**Consultation Response from KC,
Lead Local Flood Authority**

2026/90182 Land off, Hermitage Park, Lepton, Huddersfield, HD8 0JU

Discharge of details reserved by condition 17 (temporary surface water drainage) on previous permission 2022/91735 for outline application, with access and layout, for erection of 80 dwellings and associated works

Condition 17 – Construction Phase (Temporary) Drainage

Client <b>MILLER HOMES</b>		Date AUG 2025
Drawing Status <b>CONSTRUCTION</b>		Scale (m) 1:500
Project <b>HERMITAGE PARK LEPTON HUDDERSFIELD</b>		Drawn by WC
Drawing Number <b>6629-WTWD-00-XX-DR-D-9421</b>		Check by TB
Drawing Title <b>POLLUTION PREVENTION PLAN PHASE 2</b>		Revision P2

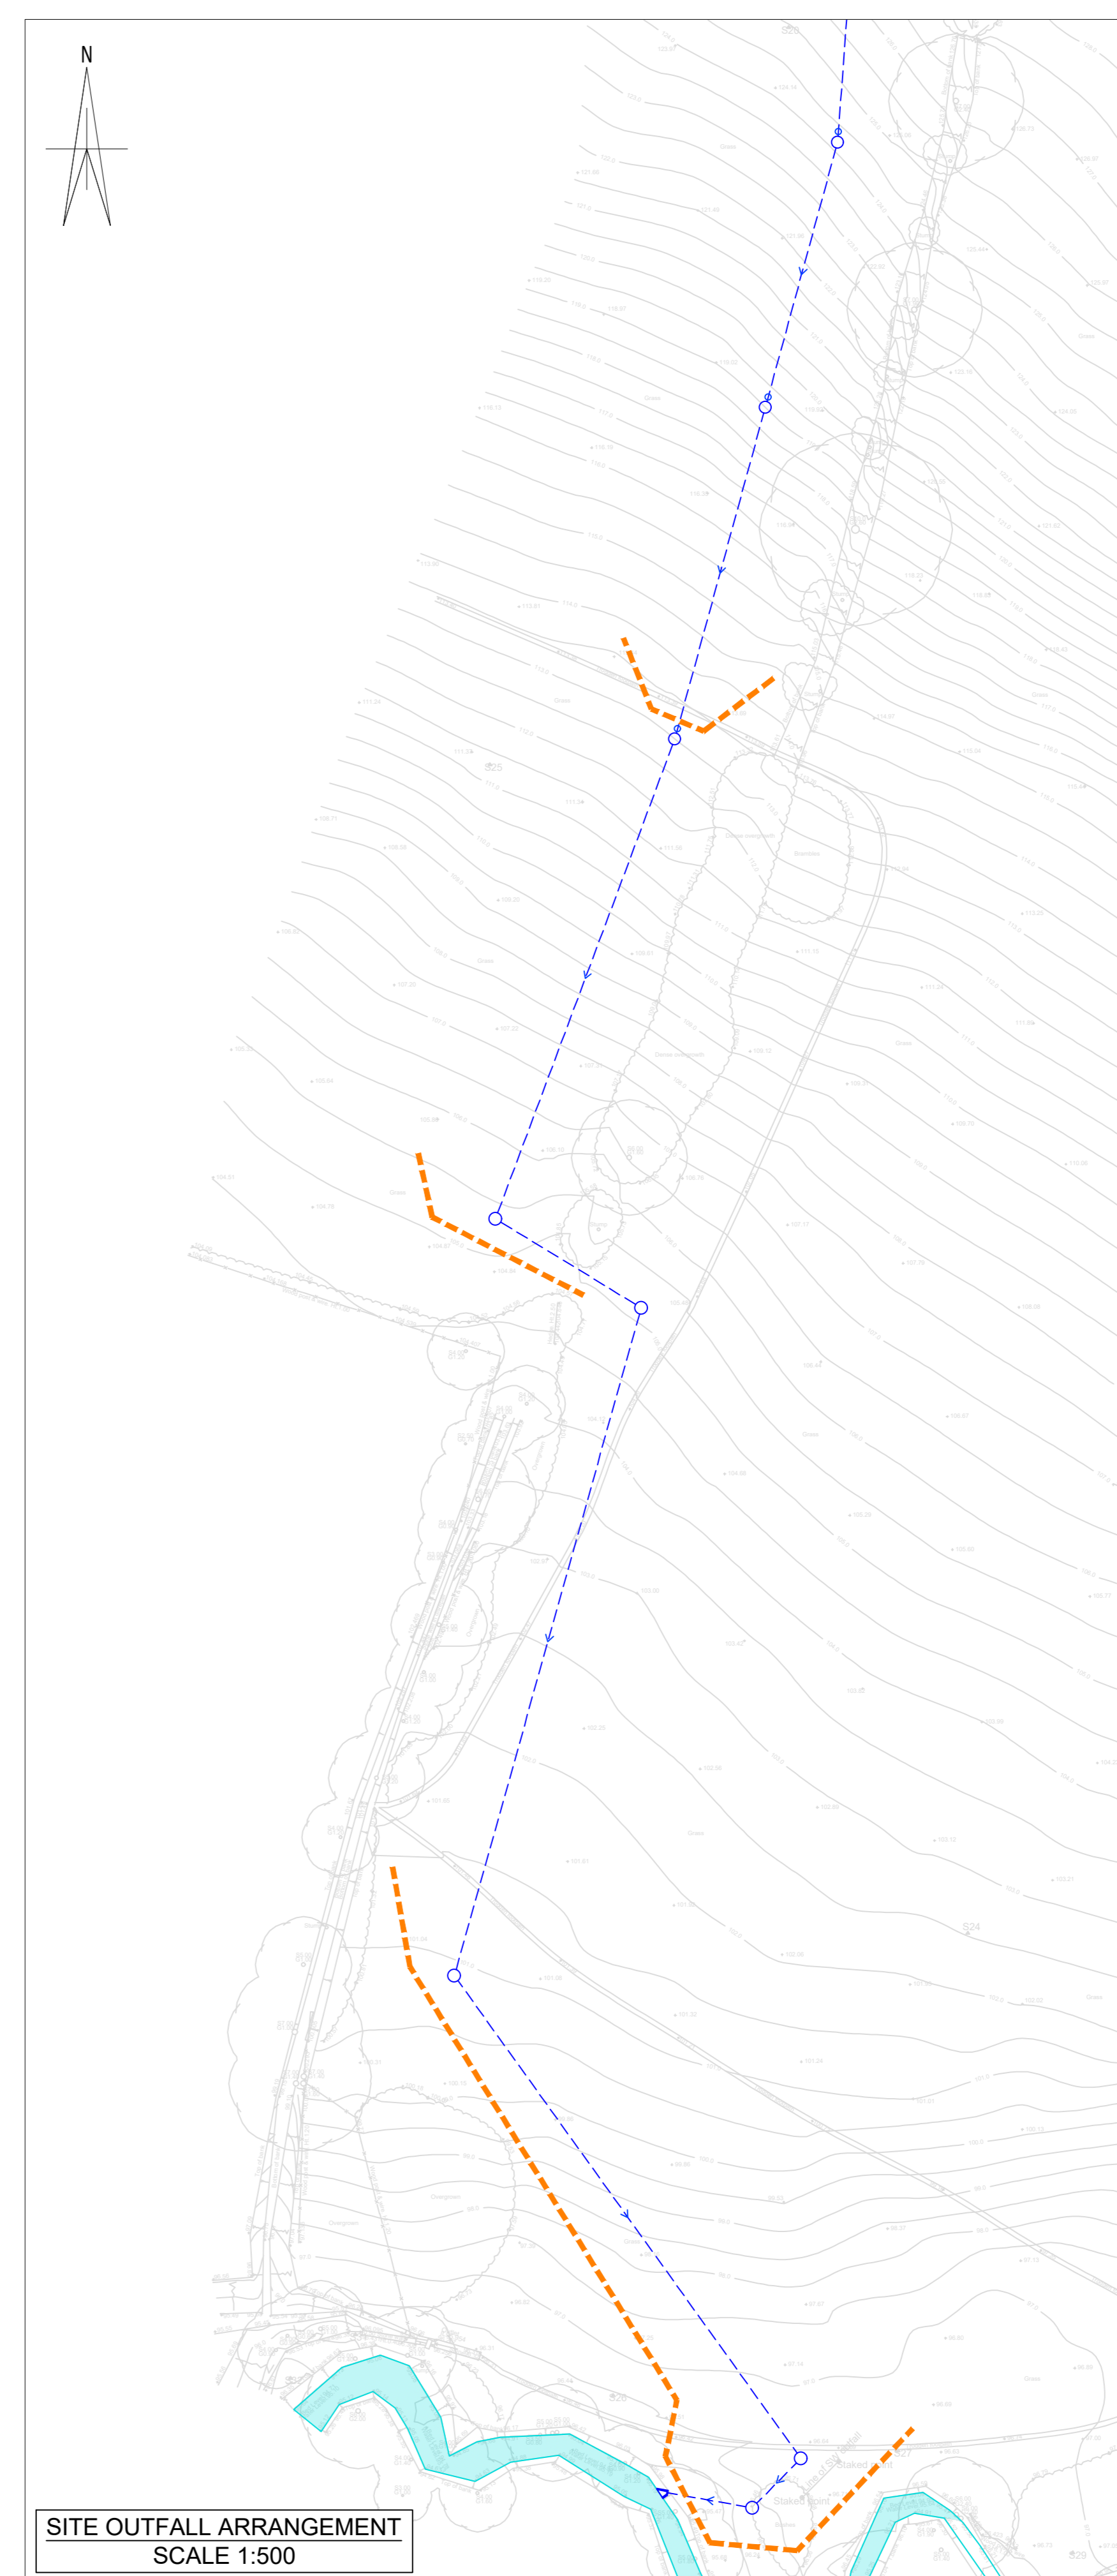
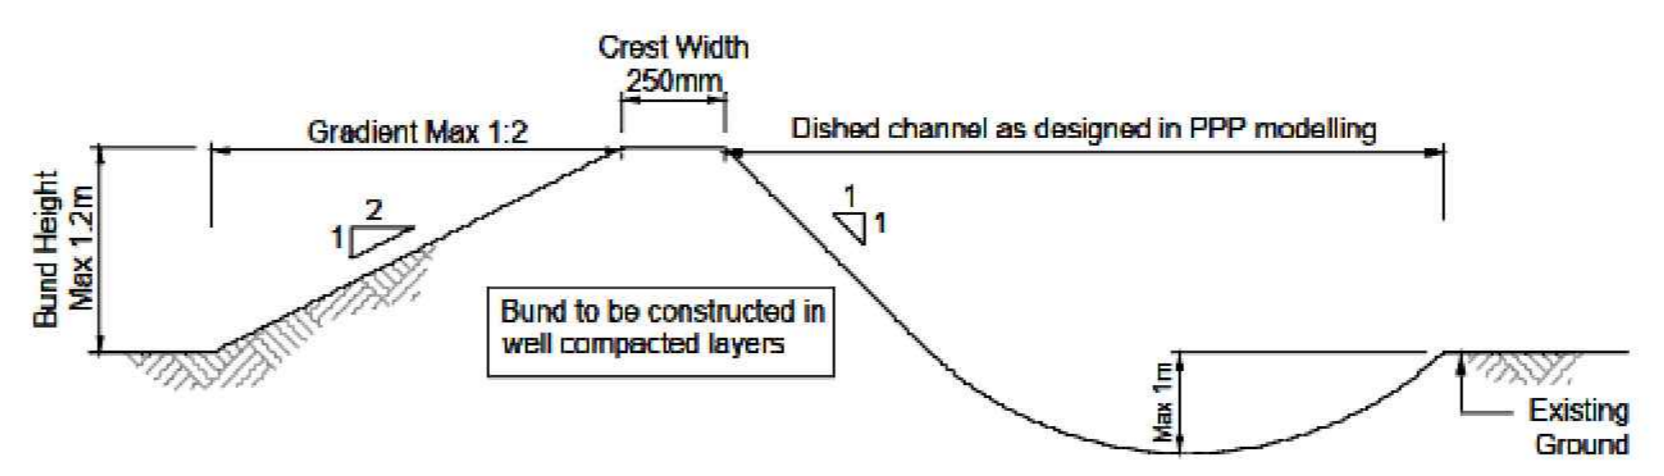
We welcome the phased approach to temporary drainage recognising that soil strip for the complete site is not required. A narrative is required to go alongside these plans. They should include an assessment of the risk in each phase including spoil heap location, risk of sediment getting into watercourses, and methodologies shown on the plans with back up plans listed such as tinkering, flocculation etc.

A final phase should describe what is required when roads and drainage are in, including sweeping roads and preventing excessive sediment getting into gullies and manholes. Clearance of ponds should also be considered once constructed. The method statements should comprise of a schedule and itinerary of tasks bespoke to this site.

The watercourse to the north-west of the site that has previously been diverted through has caused flooding recently. If this were to come through site, then a route avoiding excavation should be sought to preserve this as clean water than can be passed on.
